Application for a non-material amendment following a grant of planning permission.

Demolition of garage. Proposed porch, ground raised to provide level access, updated windows and doors, single-storey side extension, outbuilding, associated landscaping, including raised deck. Other external alterations

Reference number:	<input type="text" value="20/01607/FLH"/>
-------------------	---

DWG NO. 11617.19
© COPYRIGHT William Martin Property Consultants Limited - 7059387

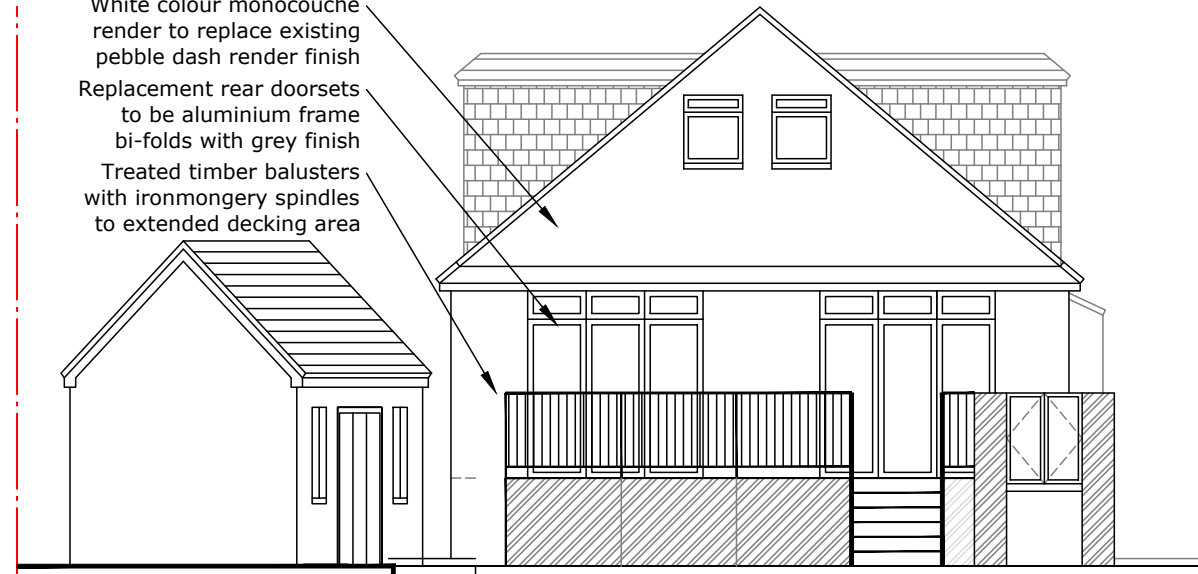
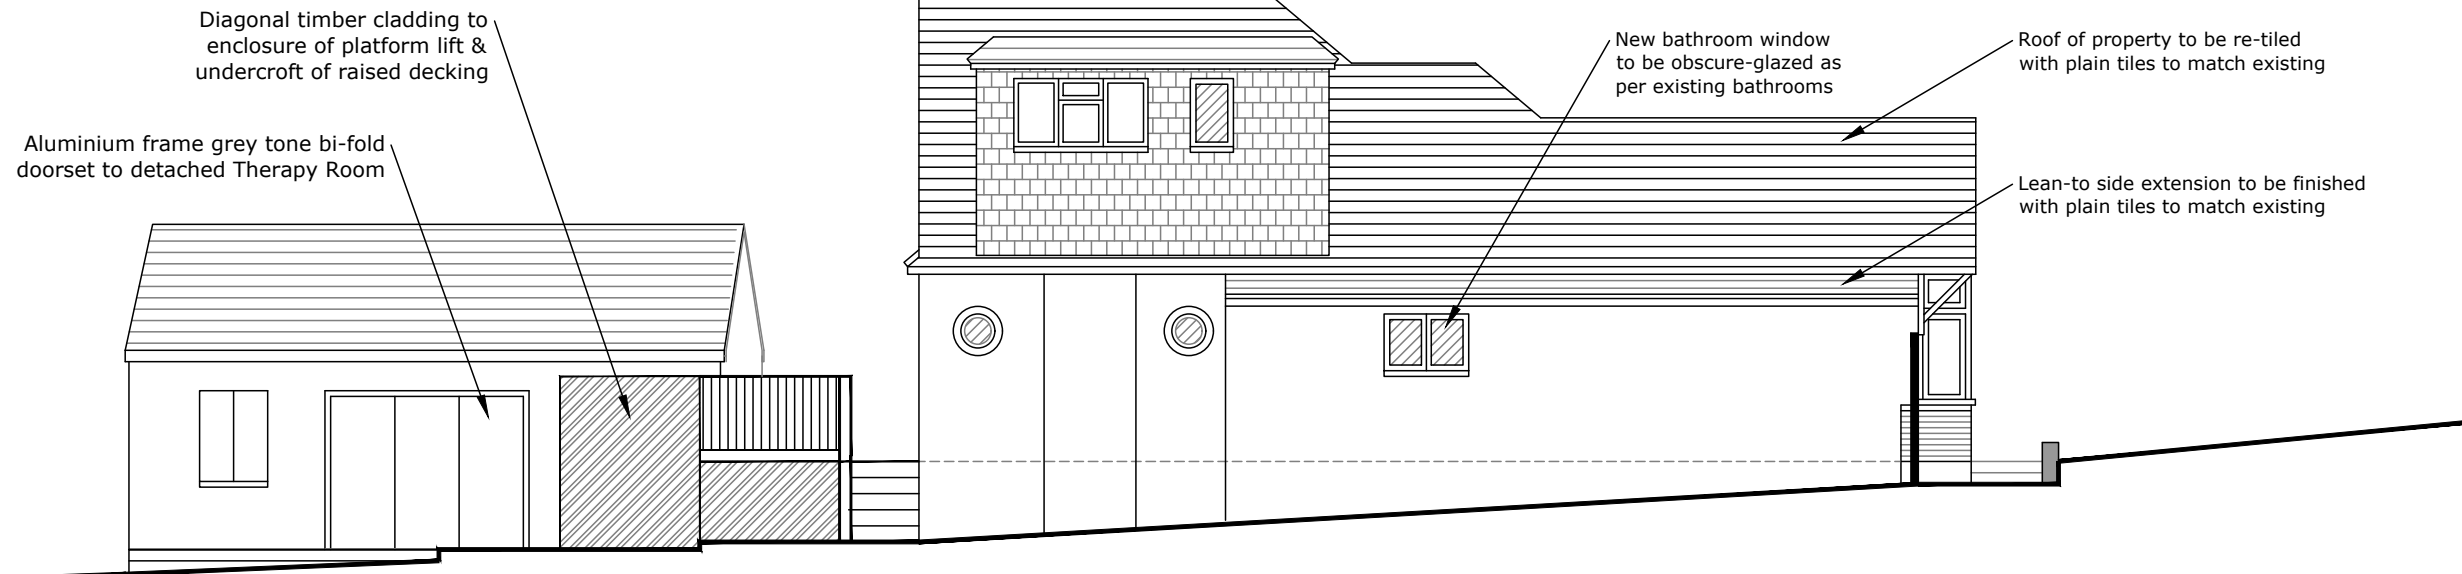
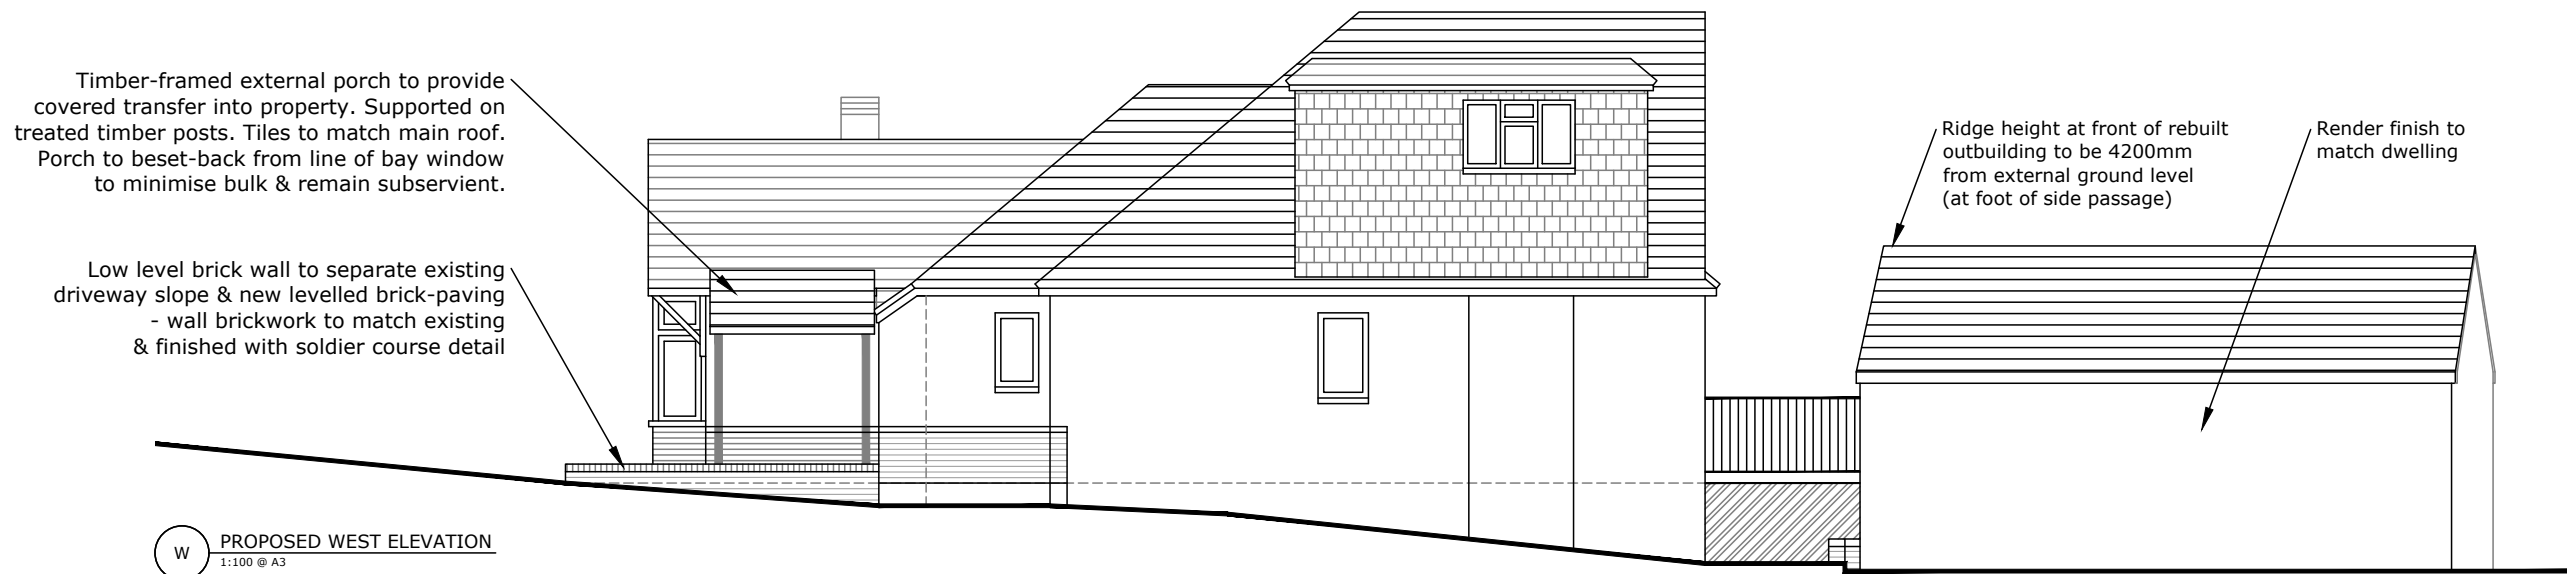
The height of the building has increased to 4.2m from ground level
The therapy room/out building has been moved away from the boundary slightly to become an independent structure

11617.16 Rev A - Proposed Ground Floor Plan - dated 12.11.2021
11617.17 Rev A - Proposed First Floor Plan - dated 12.11.2021
11617.18 Rev A - Proposed Roof Plan - dated 12.11.2021
11617.19 Rev A - Proposed Elevations - dated 12.11.2021
